**KIRKLEES METROPOLITAN COUNCIL
INVESTMENT & REGENERATION SERVICE**

Reference No: 2019/62/93626/E

Site Address: 17, Carriage Way, Heckmondwike, WF16 0NN

Description: Erection of first floor side extension and two storey rear extension

Rear Elevation.
as Proposed

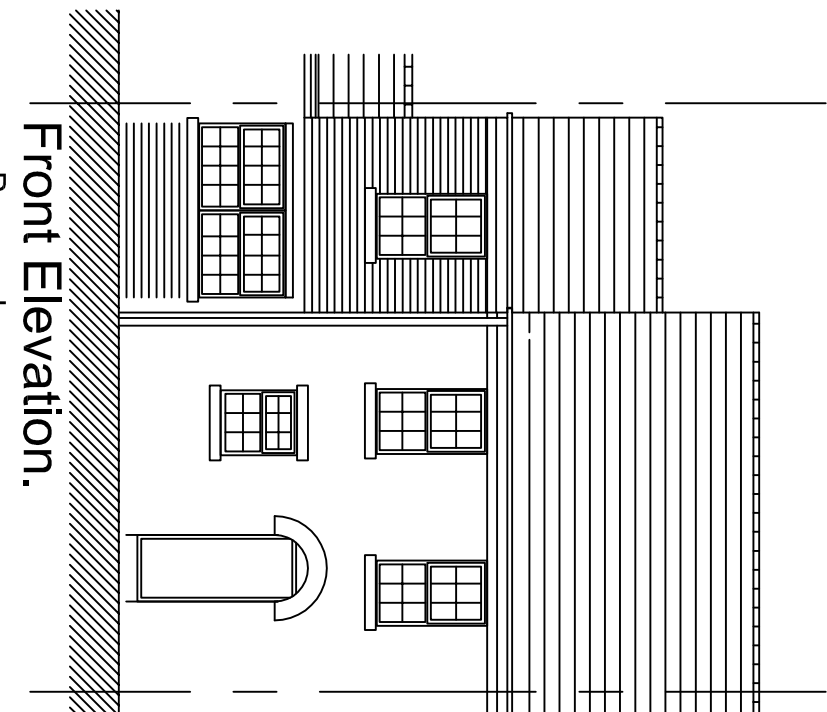
In terms of overshadowing and overbearing impact, the proposed first floor element combined with the 2-storey section that projects a further 4.0m has potential to cast additional shade. However, the eaves level would be to match the existing and the overall ridge height would be significantly lower than the host dwelling house, so in the case officer's opinion this would minimise such impacts.

Furthermore, although the proposed projection is 4.0m and close to the mutual boundary, the original rear elevation of the main habitable part of the house at 15 Carriage Way is also set back by approximately 1.5m, so beyond that level the proposal projects just 2.5m, which is considered acceptable.

Side Elevation.
as Proposed

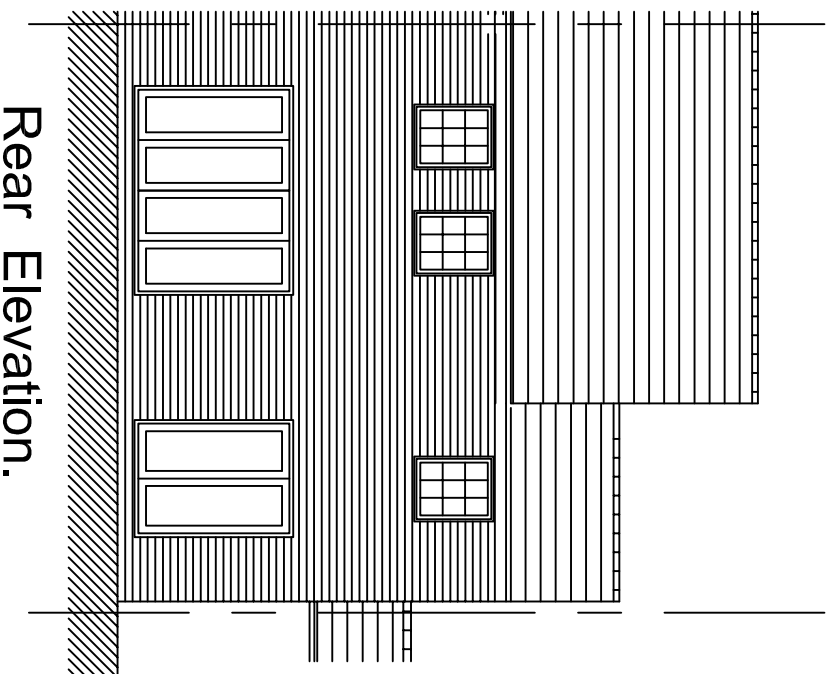
With regards to overlooking impact, the proposed side elevation, which would directly overlook 15 Carriage Way, is blank, and new openings could be controlled by condition. It is noted that an internal bathroom would be light and ventilated by a roof light on inward facing dual pitched roof slope.

6. Notwithstanding the provisions of the Town and Country Planning (General Permitted Development) (Amendment) (No.2) (England) Order 2015 as amended (or any Order revoking or re-enacting that Order) no doors, windows or any other openings (apart from any expressly allowed by this permission) shall be created in the west facing side elevation of the extension hereby approved.

Response: During the course of the application, the scale of the proposal has been reduced and windows in the side elevation removed. Together with a condition removing permitted development rights for additional openings in the side elevation, there would be no overlooking impact to neighbouring properties.
